ASPS-ID/OUT/2011/AF8958560

**ENVIRONMENTAL ASSESSMENT – WATER RELATED SERVICES FOR THE
NORTH WEST GROWTH CENTRE - SECOND RELEASE PRECINCTS –
APPLICATION No 10_0211 - SUBMISSION IN RESPONSE TO PUBLIC
EXHIBITION**

**Indicative Services for Schofields**

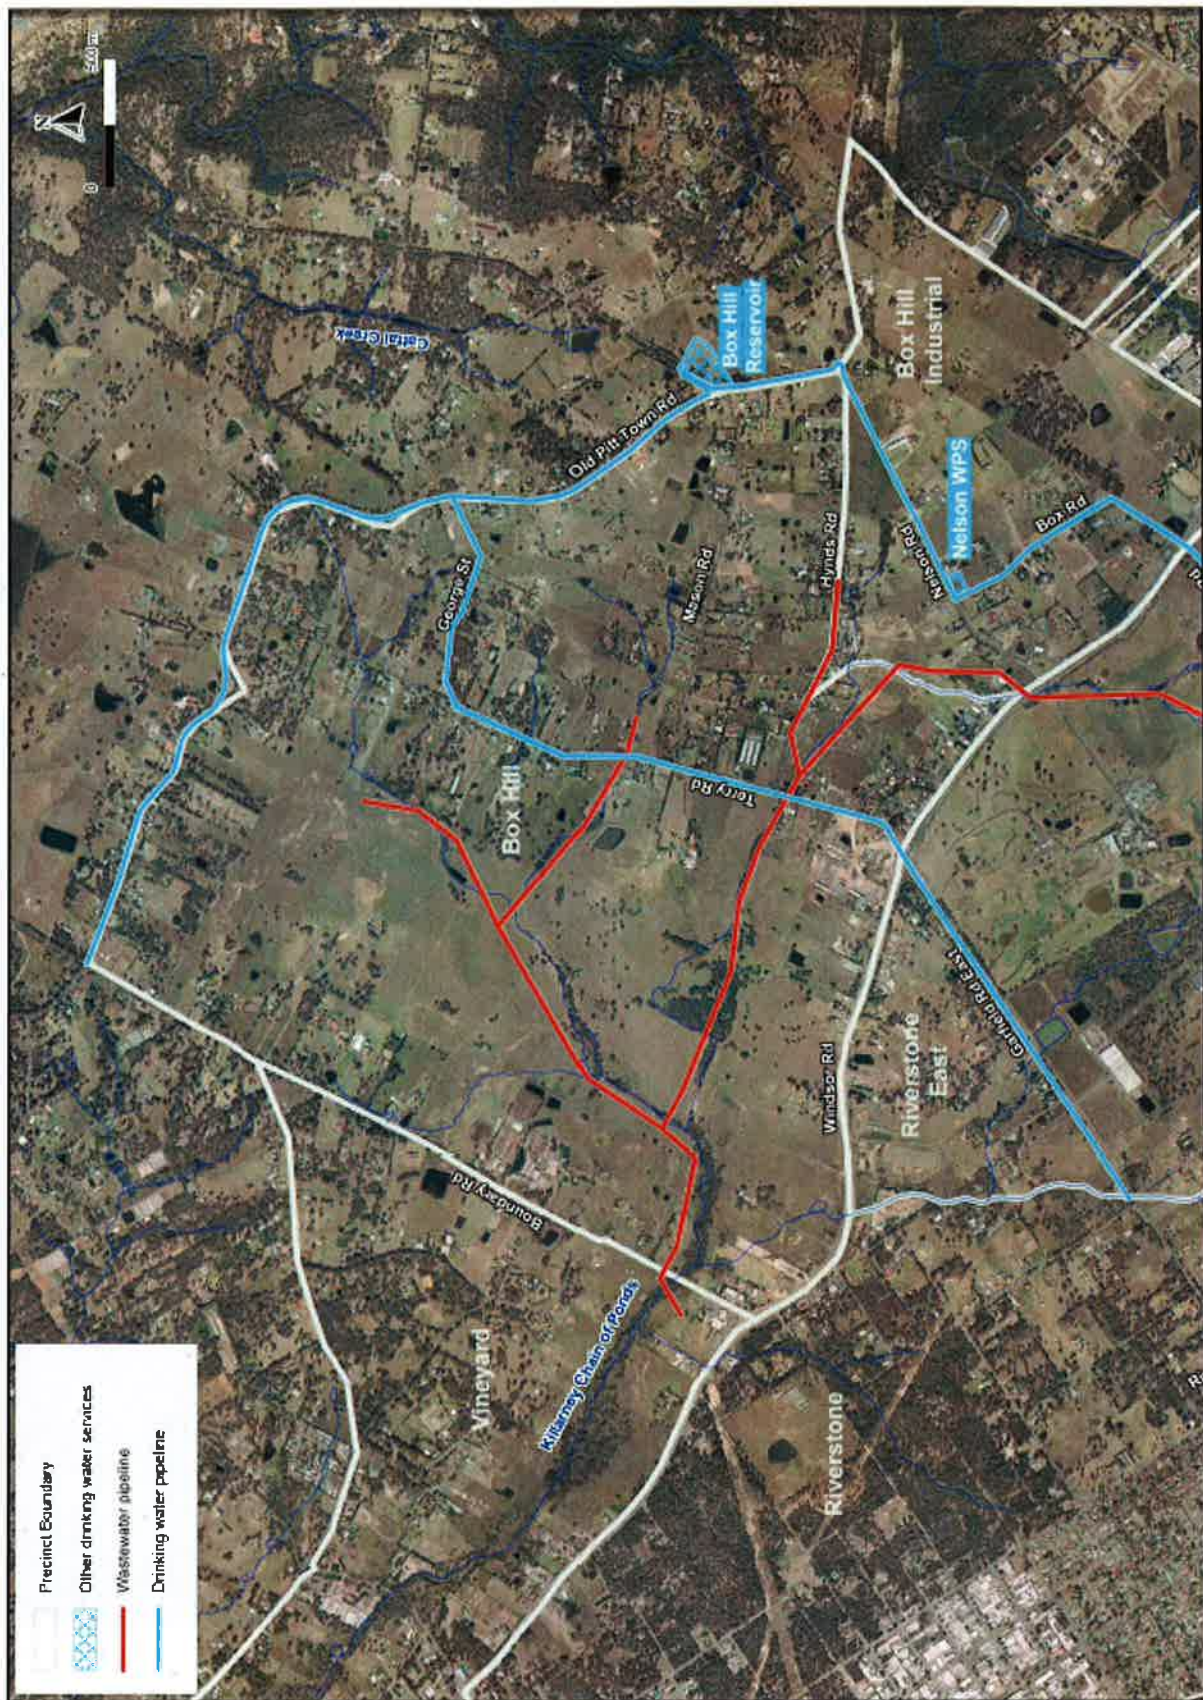
The EA document purports to describe the provision of "water related services to support the development of the second release precincts" (pii, pxxi, p1, p11 etc) including the Schofields Precinct. Defence was therefore expecting the water servicing required for development of the Defence Site to be described and assessed in the EA. The only reference Defence could find concerning the omission of the Defence Site was under a sub-heading "Commonwealth land" (p43) which stated "The Proposal is outside the three areas of Commonwealth land in the NWGC at Shanes Park, Schofields Aerodrome, and a Telstra property in Riverstone." Yet elsewhere in the EA the "Proposal" is defined and described as servicing the Schofields Precinct which clearly includes "Schofields Aerodrome". The supporting figures in the EA also omitted to show the trunk infrastructure that would be required on the Defence Site.

Under Section 3.4 "Proposal Staging" there is no description of the proposed staging of the infrastructure, no schedules and no timelines for the Defence Site. This section refers to Figure 3-5 which purportedly "shows indicative staging for the Proposal up to 2025". The trunk water infrastructure necessary to service the Defence Site is not shown on this figure.

Defence located a plan on the SWC website dated October 2011 titled "Schofields Indicative Water and Wastewater Servicing Plan". This Servicing Plan shows the indicative location of trunk water infrastructure on the Defence Site and describes its provision as part of "Package 3 Trunk water and waste water available by 2020". The information presented in this Plan was not included in the EA.

- SWC indicated that it intended to move the location of the water main stub under the railway line further south and closer to the Defence Site. It also indicated there may be minor amendments to the location of the wastewater main. These changes do not reduce but exacerbate the potential difficulties that a developer/s on the Defence Site may face in the survey, environmental and engineering assessment, design and construction of trunk water facilities on land owned by third parties and potentially development competitors.

- Defence suggested to SWC that the trunk water stub under the railway line should be moved further south at least to the Defence boundary or extended to the Defence boundary to facilitate servicing of the Defence Site.
- SWC further advised that if the developer constructed the trunk water infrastructure, the costs could be claimed back from SWC so long as SWC's procurement guidelines had been followed.

- prepares an addendum to the EA;
- undertakes survey, environmental assessment and design for those parts of the Schofields Precinct omitted from the EA dated October 2011;
- constructs trunk water and waste water infrastructure for the whole Precinct; and
- brings forward the proposed servicing of the southern part of the Precinct on the Defence Site.
